RE Planning Application number 2019/61/91327/W

Planning Application number 2019/61/91327/W
Summary of Recommendations

5_Service Yard Elevation (E) 1: 200

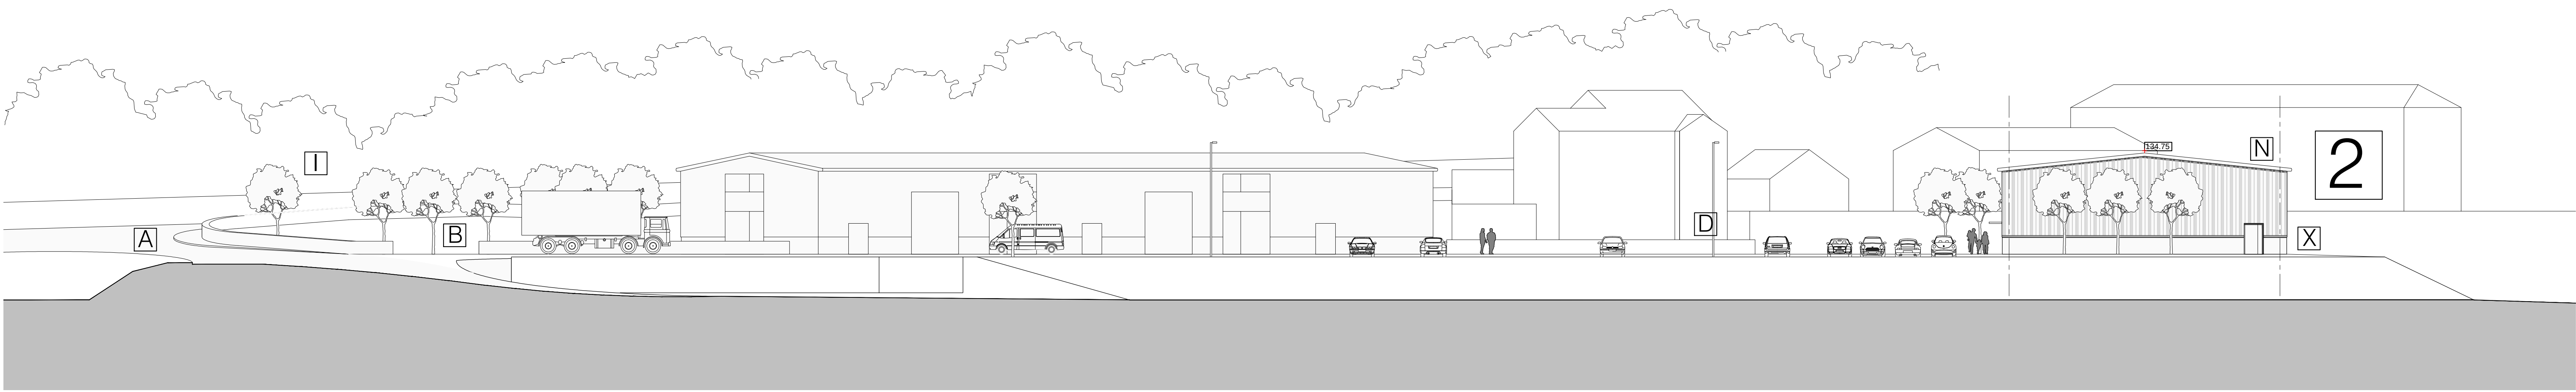
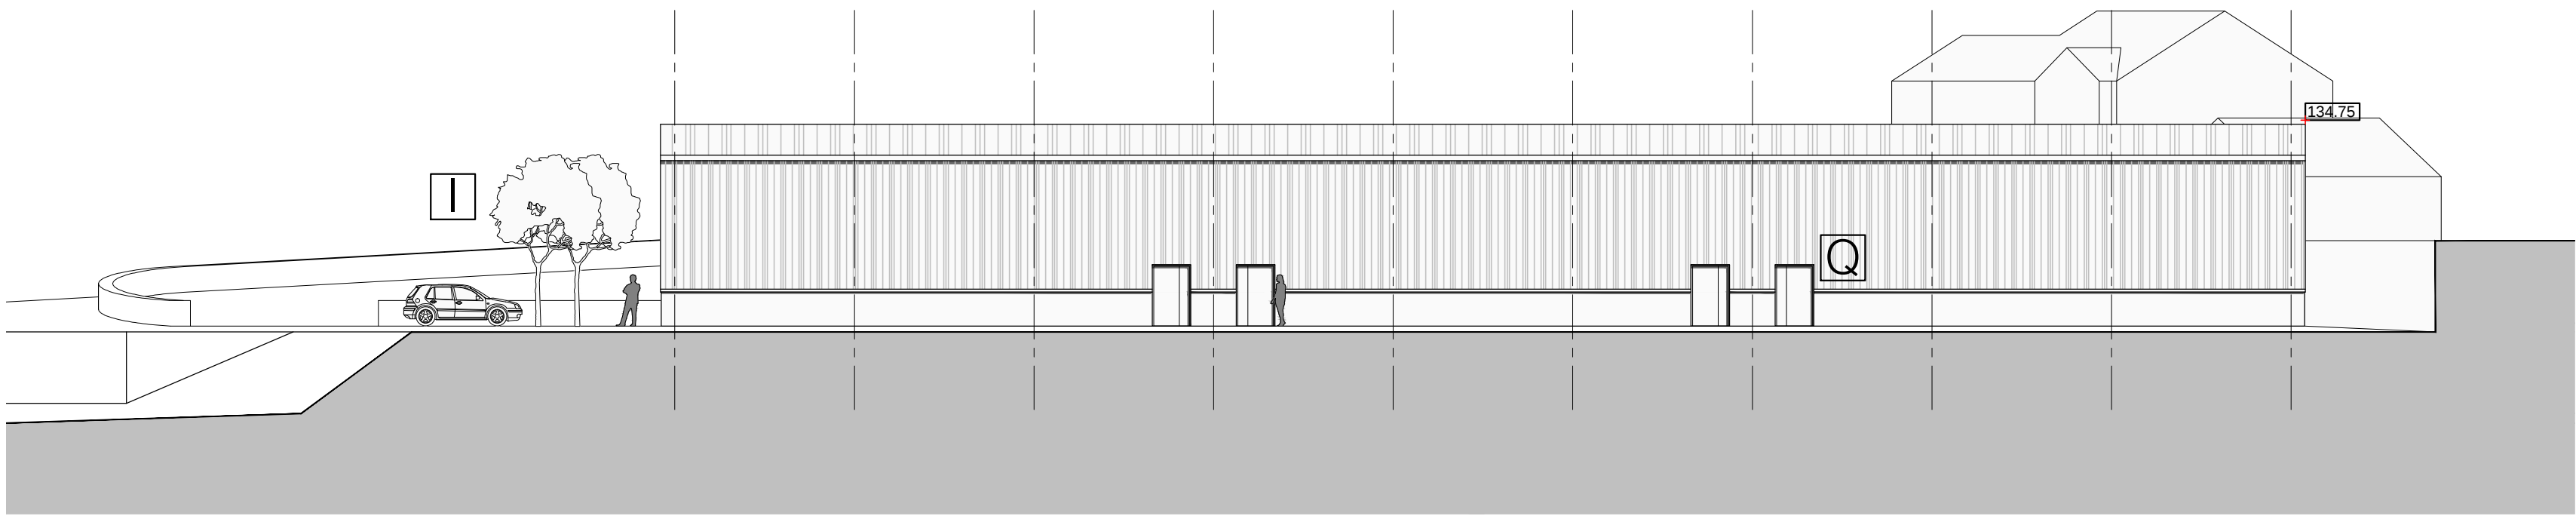
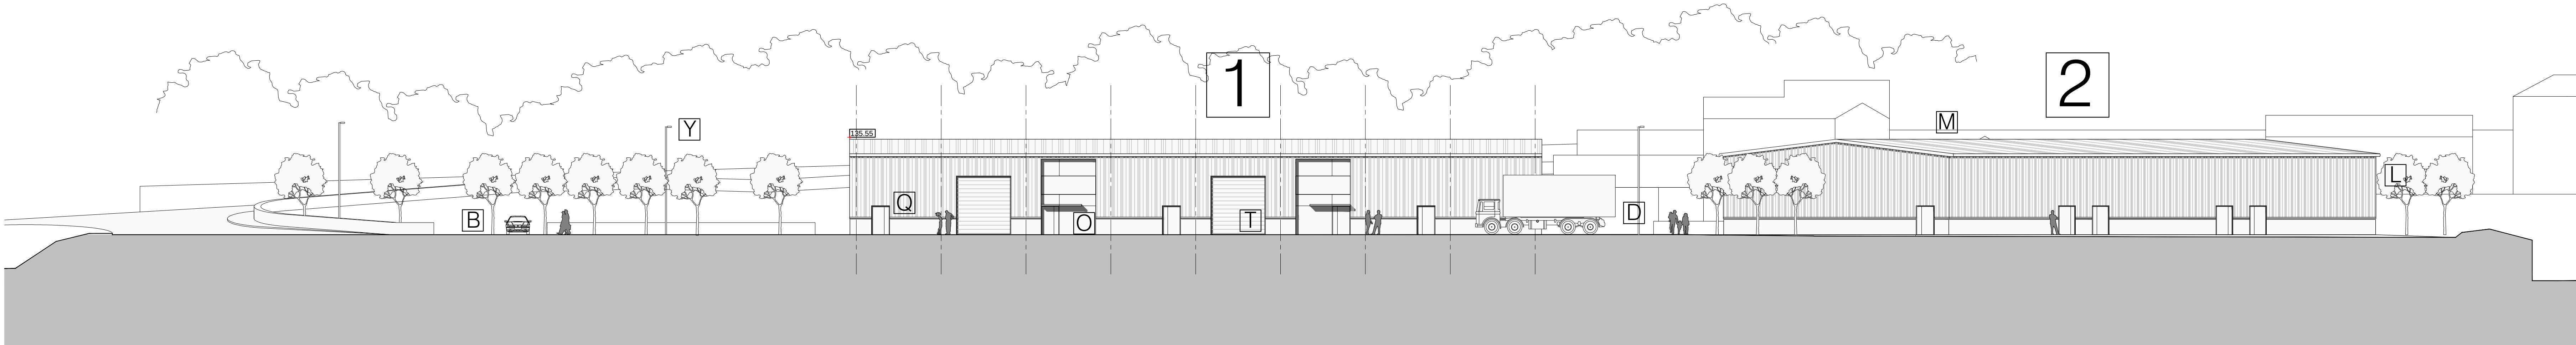
Therefore, we would like the eastern perimeter of the site to be contained with acoustic barrier fencing of a sufficient height (minimum 6 meters) to baffle noise from the site and to screen it from our view and vice versa. This should be of treated wood or painted a drab green.

Our understanding from the plans is that the proposed lamps will be 9 meters tall. We would like to ensure the lamps are lower than the top of the perimeter fence, should point downwards and are 'dark sky friendly'

1) The eastern perimeter of the site (facing the Miry Lane terrace) to be contained with acoustic barrier fencing of a sufficient height (minimum 6 meters) to contain noise within the site and also to screen the site from our view and vice versa. This should be treated wood or painted a drab green.

3) The site should not be continually lit during the night. All lamps should be lower than the perimeter fence and be 'dark sky friendly'
